RE: 189 St John/Maine Med

D Street Side Walk Impacts to [189 St. John Street](#) property

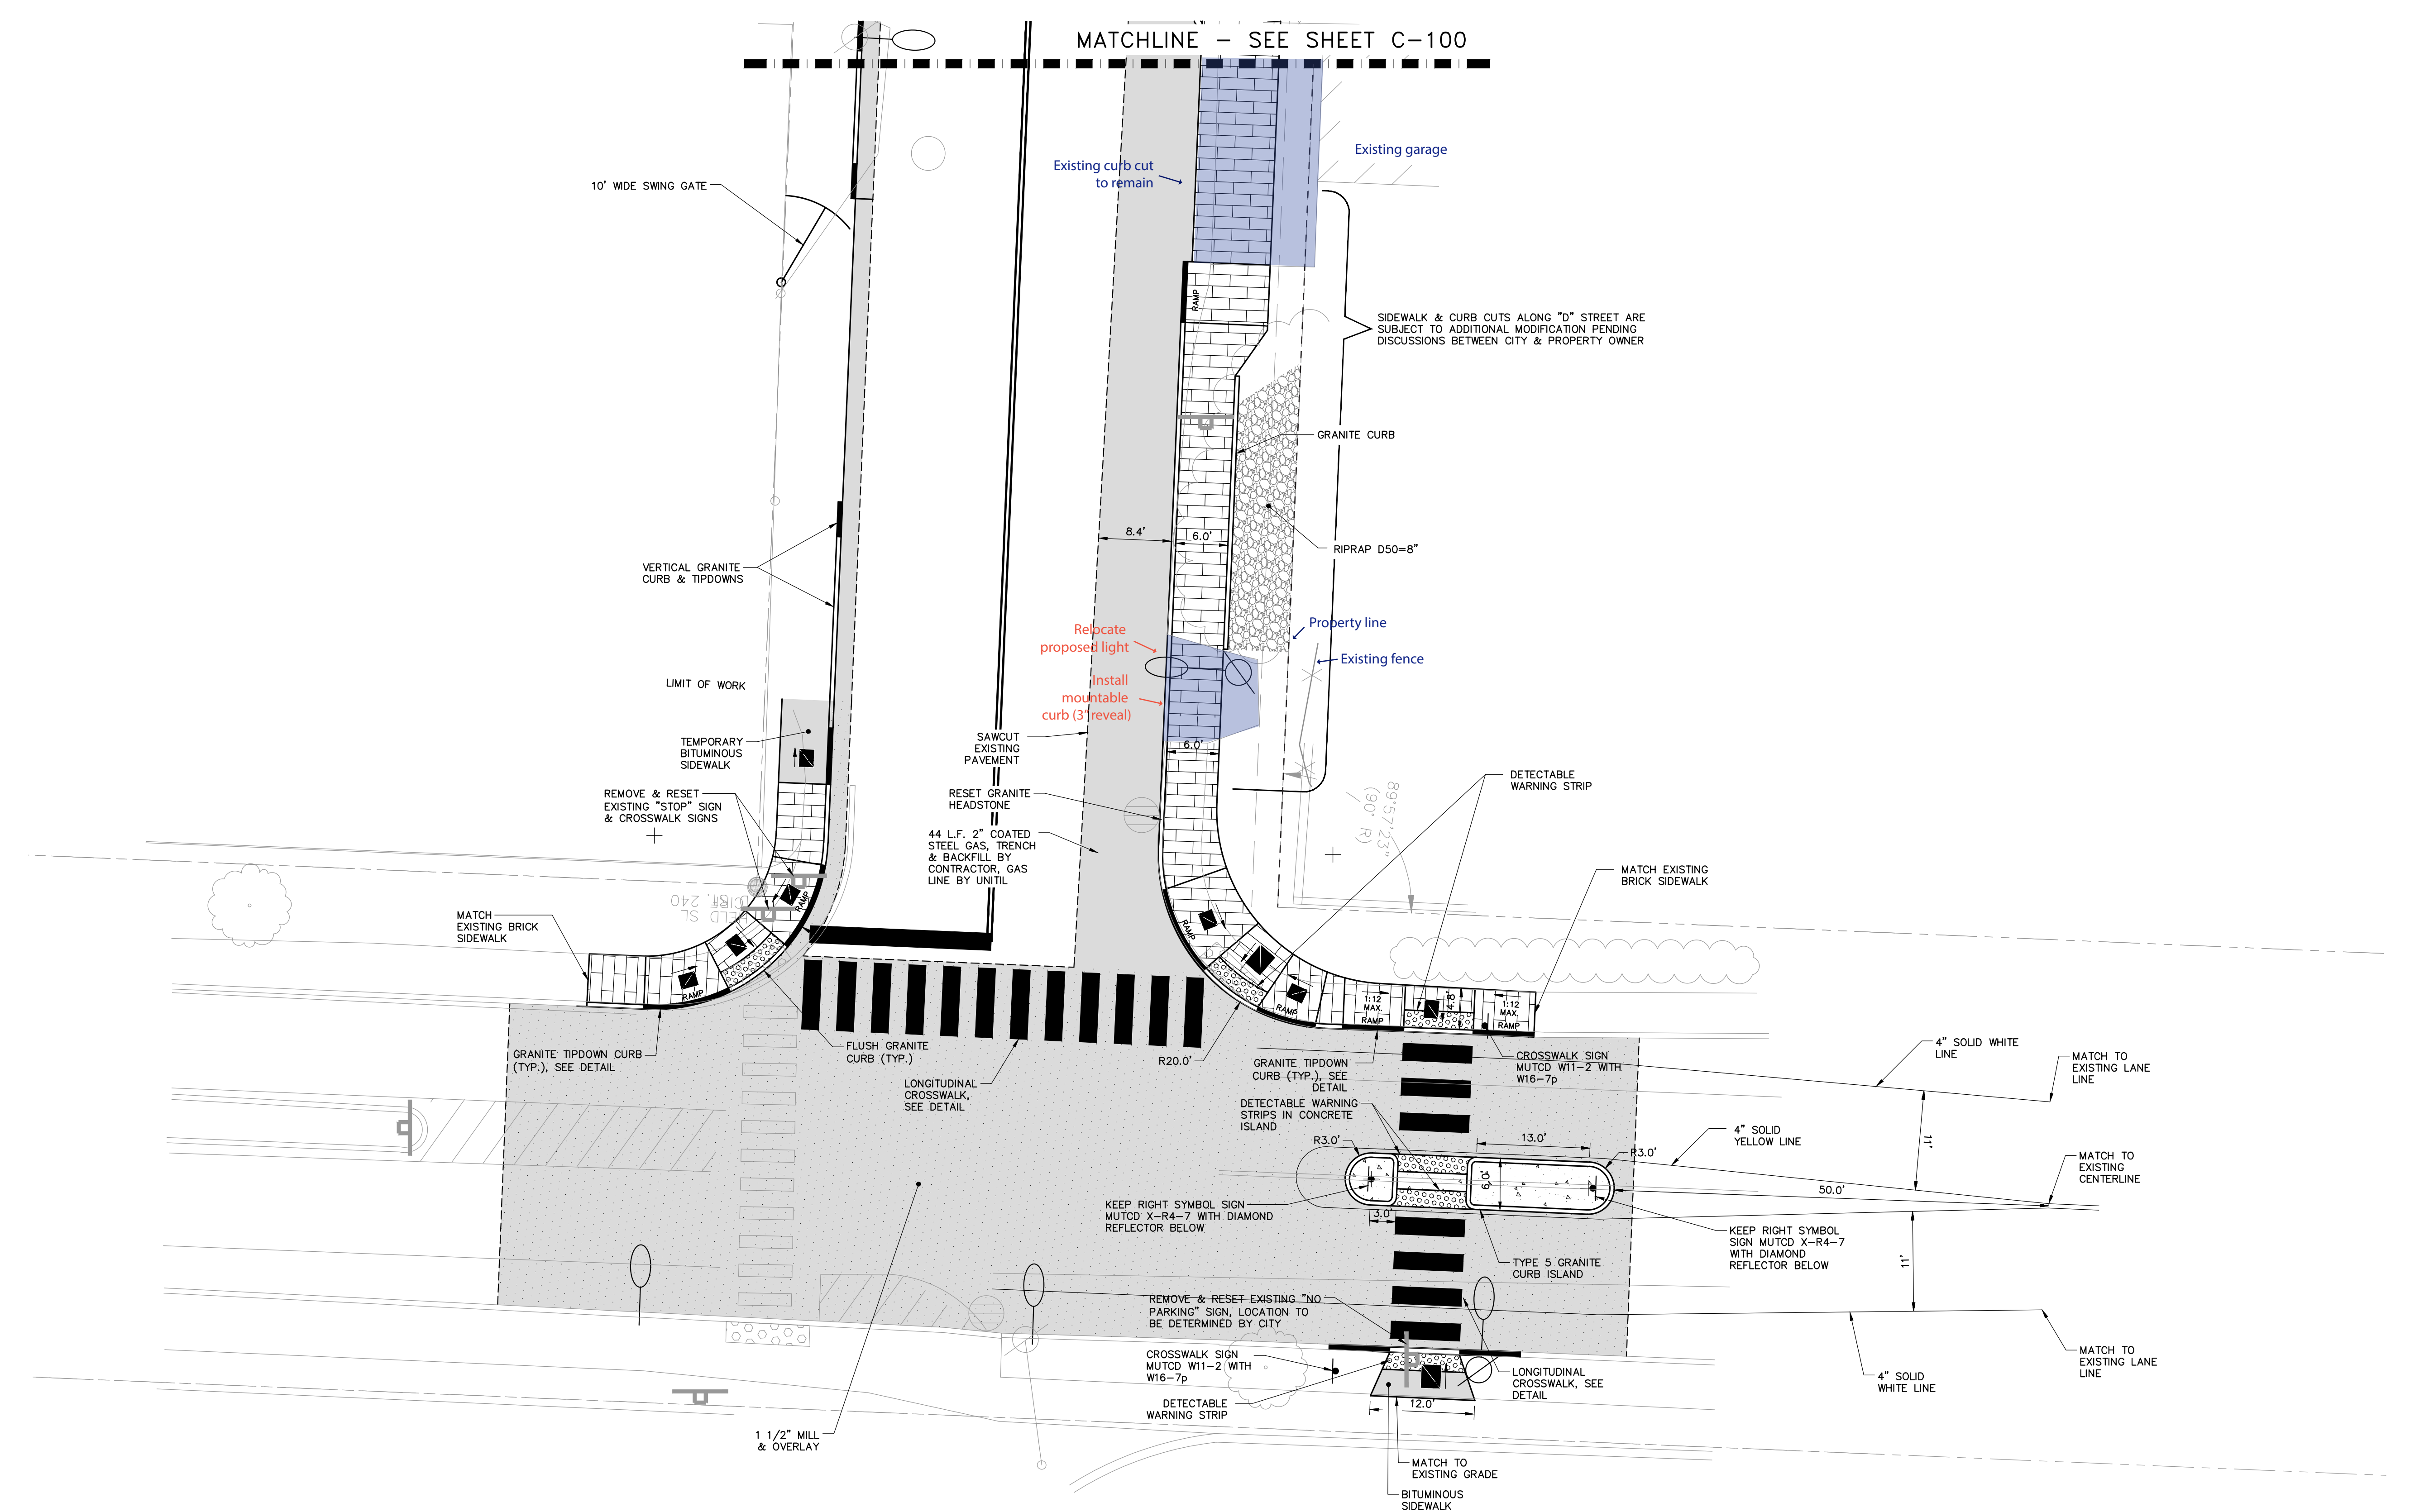
Our first request would be that the city consider putting the sidewalk on the other side of D street, rather than the proposed side in the plan, since it would be much less of a disruption to our neighbor, who said he doesn't care, than to us. One of the most important reasons to consider the other side is the very significant loss of mature plantings and tree. These impacts make up the bulk of our concerns listed below.

1) The large, mature poplar tree on the corner of D and St. John has been pruned and maintained at our expense over the years. This is a very significant shade tree for our property and a big "tree presence" in this part of the neighborhood. We have had at least 4 visits to our property to maintain this tree and others, most recently by Southern Maine Tree Service. The loss of this tree will have a huge impact on the shade it provides our property, especially in the afternoons. It also provides an aesthetic component that all mature trees offer. This loss will be replaced by large traffic light poles, wires, traffic lights etc.. We would like to see more tree wells and trees planted to at least attempt to add a softening to the changes coming. We understand that no new trees will be significant in terms of shade for our property, nor will they block the poles, wires, and traffic signals, however, they might provide a bit of softening and a bit of compensation for the loss of greenery.

2) It appears that the mature forsythia bush, all the mature lilac bushes, and the established vinca vine (ground cover) will be lost in this work. These were all planted by my wife and me. Their loss also impacts our property by the loss of color, and fragrance, and the softening of visual and aural aspects of living on a busy corner. Also, they protected the fence from becoming a target for vandalism. There was significant cost and labor involved with these plantings, not to mention a bit of an emotional attachment that has developed as they have grown. However, we understand that they are on city property, we only ask that Mr. Tarling include some plant screening that he sees fit, in between the sidewalk and the fence, to replace some of what is being lost. Lastly, we will ask a landscaping company that we have used in the past about transplanting the lilacs and forsythia to the inside the fence. We would hope to be compensated for this work.

3) We understand the fence at the end of our driveway will need to be pushed back and we'd like to request that Maine Medical Center pay for the cost of this. We put this fence in in phases due to the cost and were not anticipating needing to move it, since until the expansion, the city hasn't shown any interest in adding a sidewalk to the area. We anticipate that we would also lose a parking space because our drive way would have to be modified to fit between the hemlock (approximately 60' tall) and the white pine (approximately 80'). Currently we can fit 3 cars in the driveway, that would reduce us to 2 spots. This loss has a big impact on the value of our property. No doubt about the loss of parking, but also the loss of a large piece of our backyard changing to driveway. In this zone we have invested a great deal of money in the landscaping on the inside of the fence. We'd be happy to meet with you if it can be scheduled, but otherwise, please feel free to enter the driveway gate and inspect our lovely "city yard and garden" when you get the chance.
